LOCKLEAR, LOCKLEAR & JACOBS, PLLC

August 13, 2023

**RE: Harnett HS Press Box Replacement
(Header and Corner Structural Review)**

FINAL RELEASED FOR CONSTRUCTION

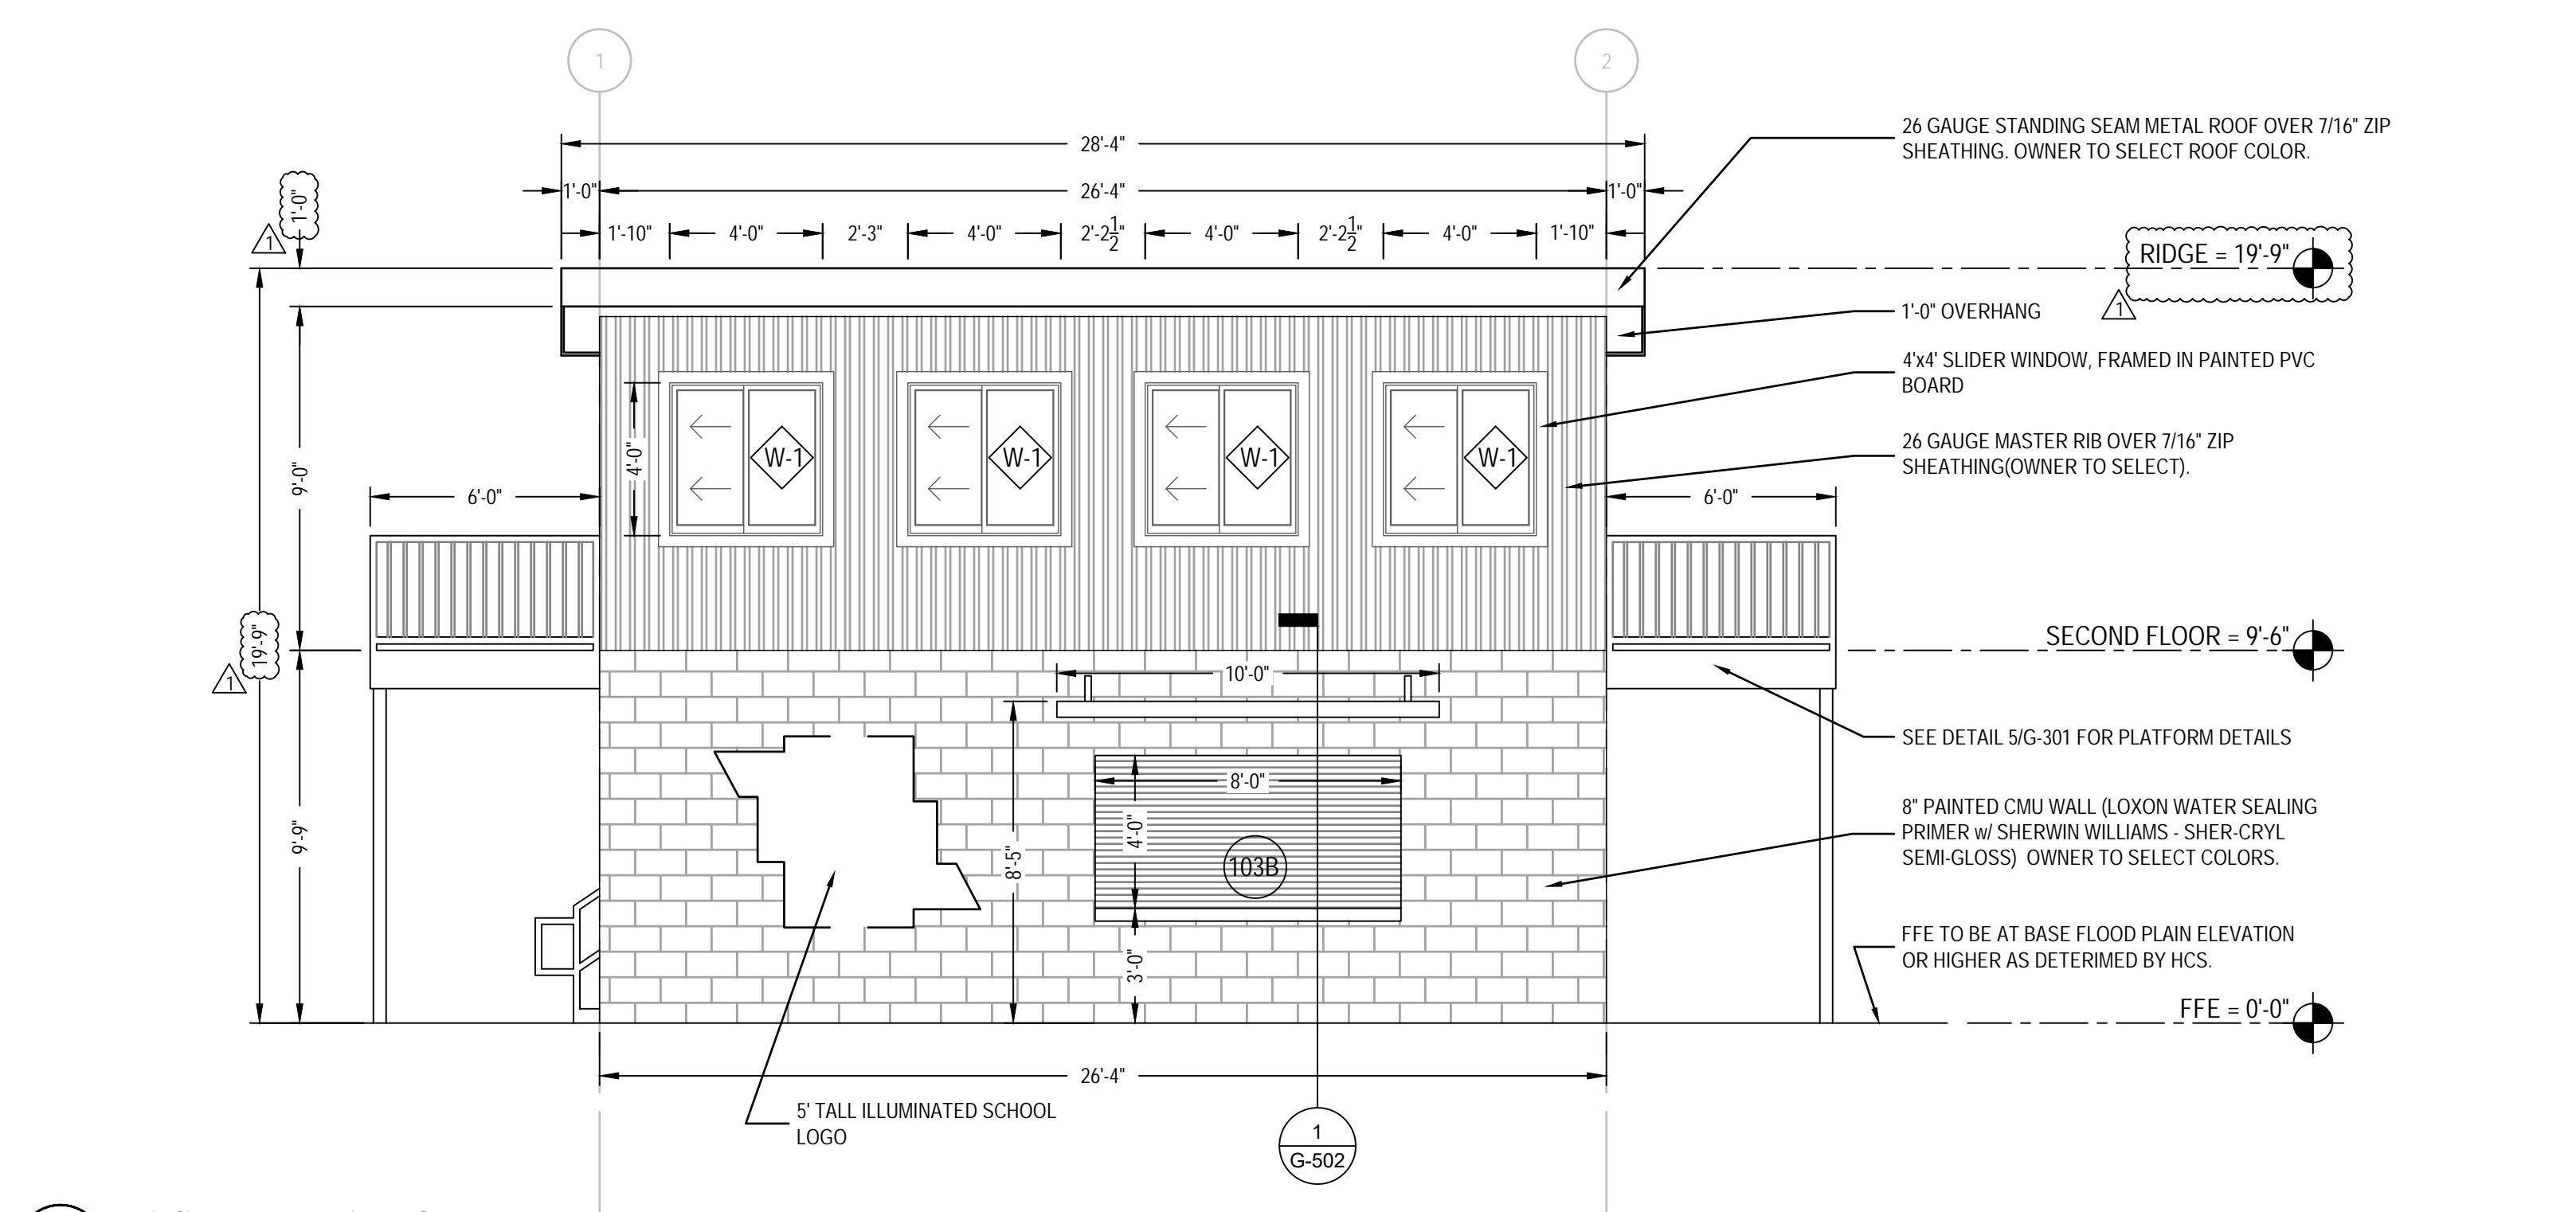
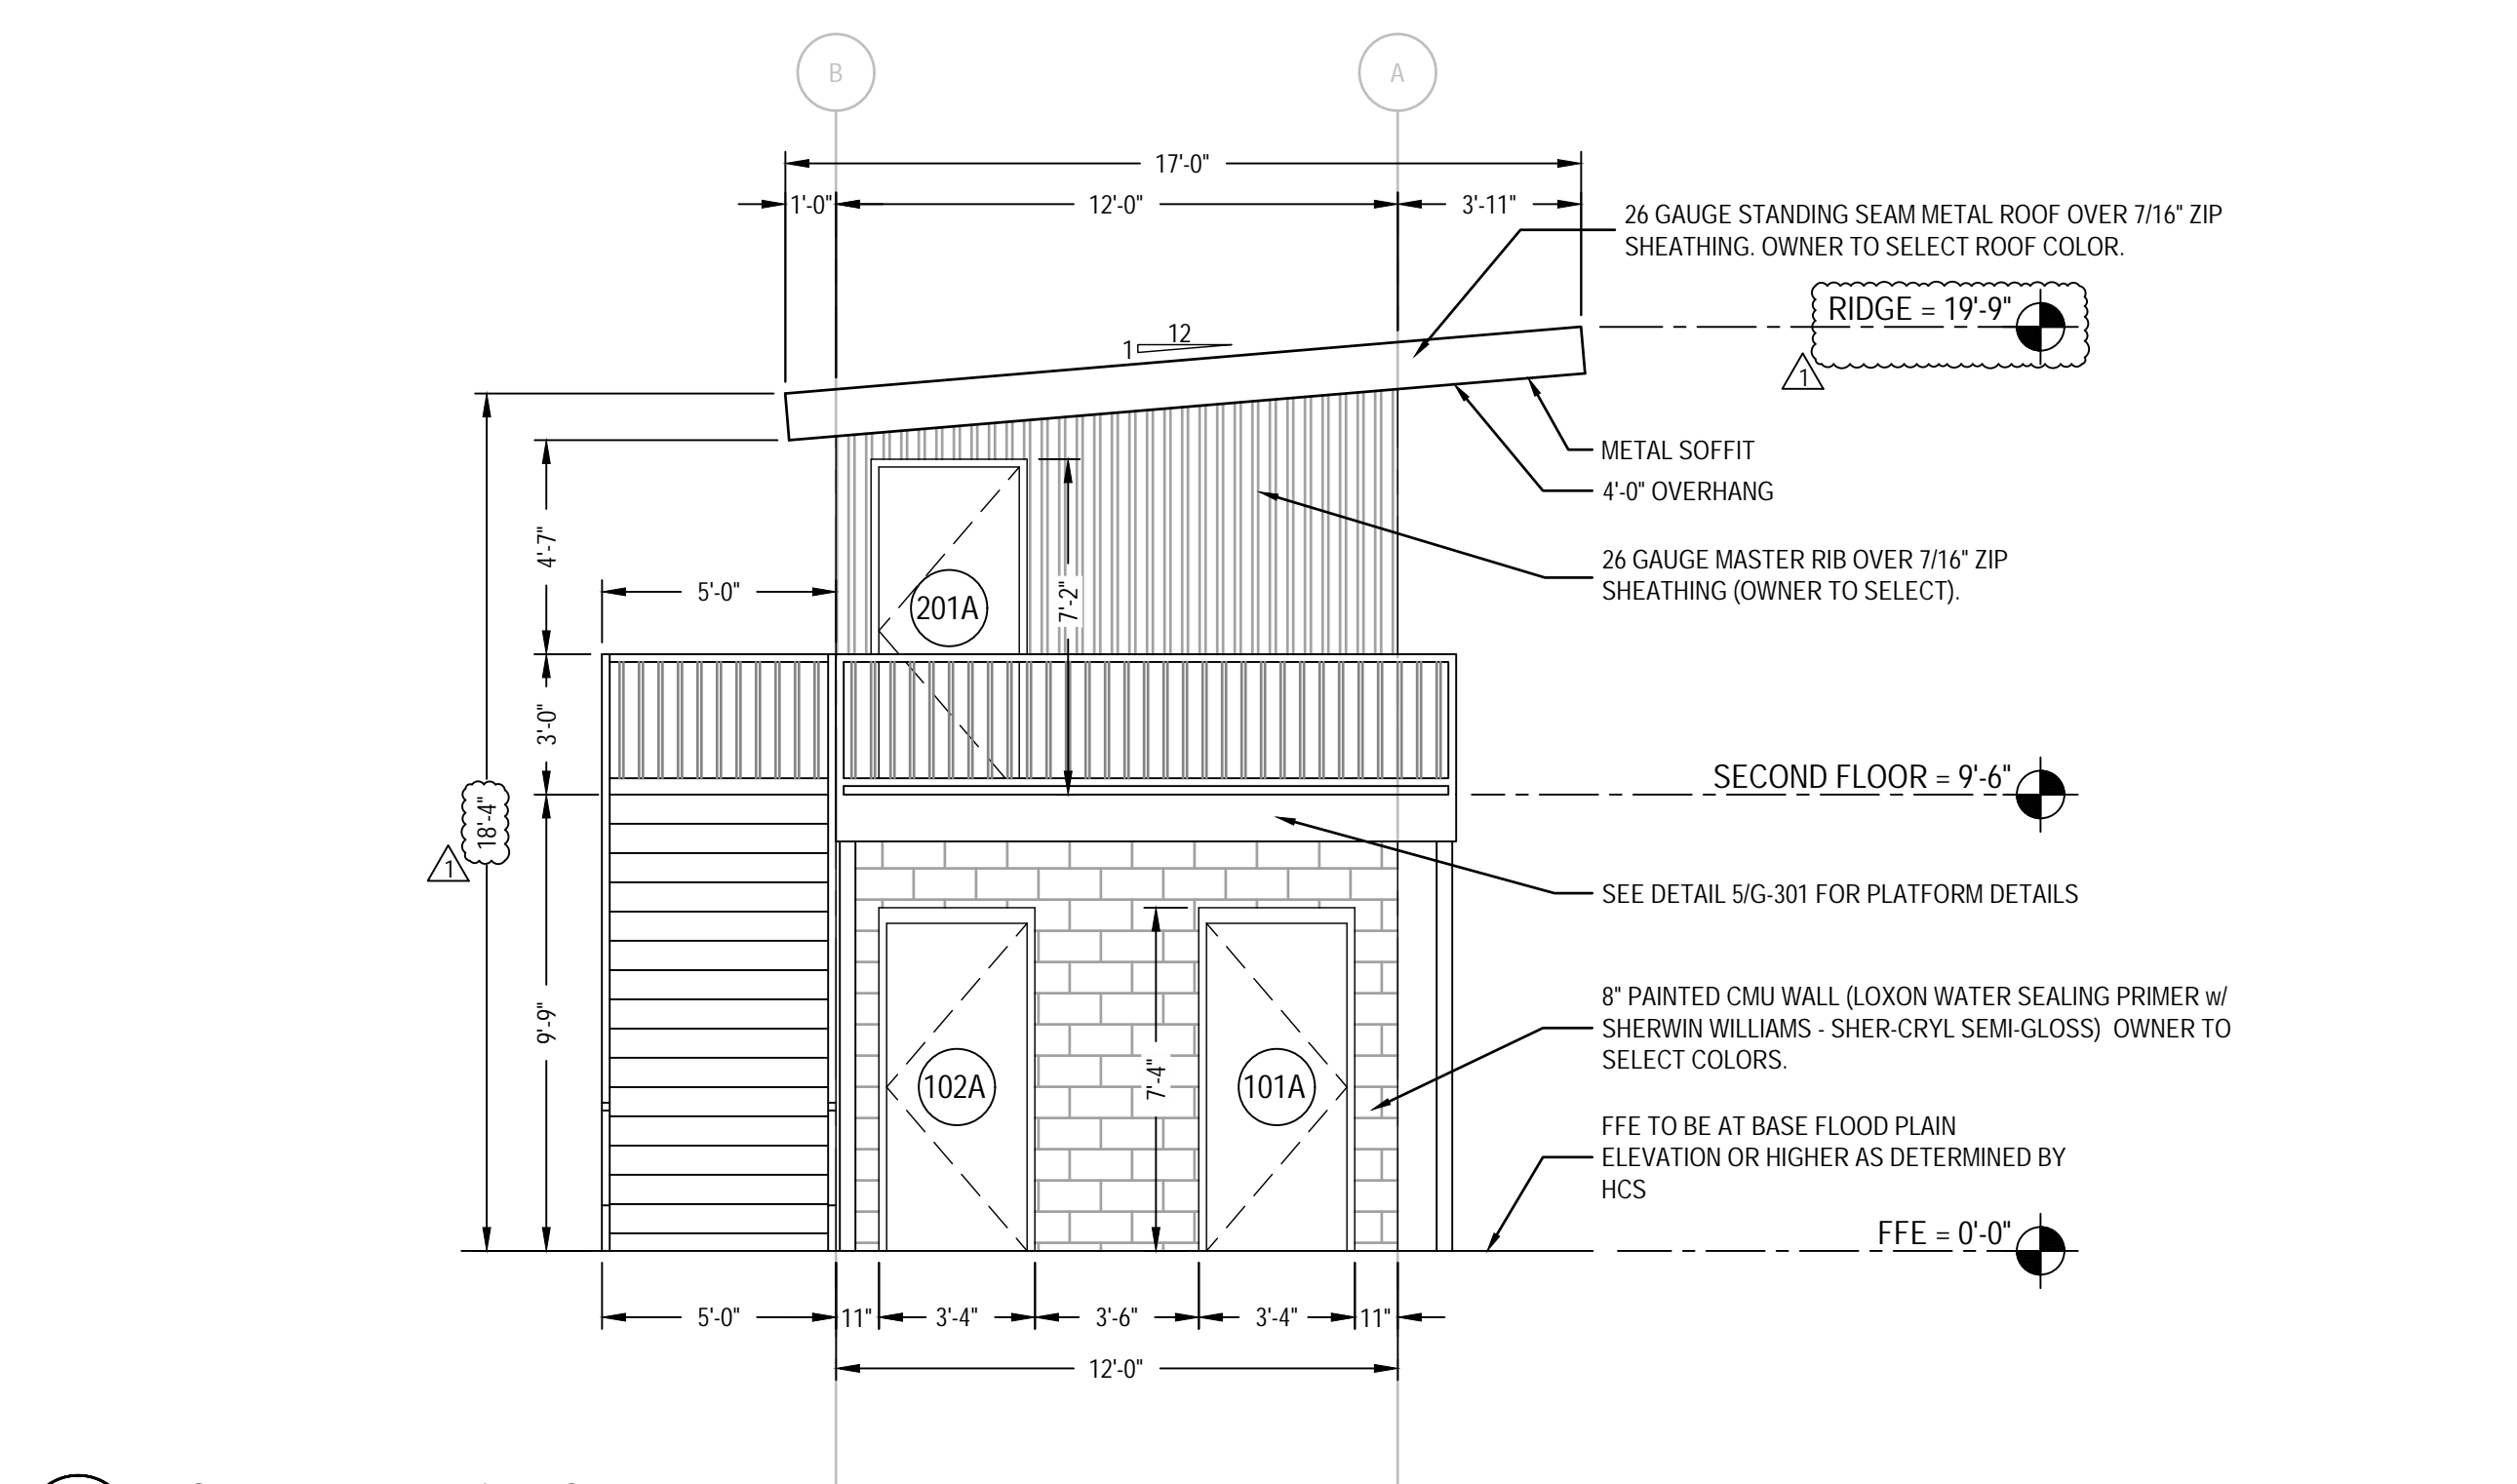
- The exterior door headers on the 2nd floor of both did not match the plans due to height restrictions and
- The corner studs we rearranged from the typical 3 stud fashion and was changed to a “U” shape layout.

- Exterior Door Headers – A review of the door header on the Western Wall at Harnett Central and the Eastern Wall on Westen Harnett was performed to check the current header as is. Both headers are sufficient. The other exterior doors on the endwalls of the building are framed in solid and have minimum load on them. They are sufficient as well.
- The contractor was advised to block in the corner studs at a minimum of 3rd points and attached these members so they for a typical corner stud situation. This should correct the framing modifications and the corners studs should be sufficient as well.
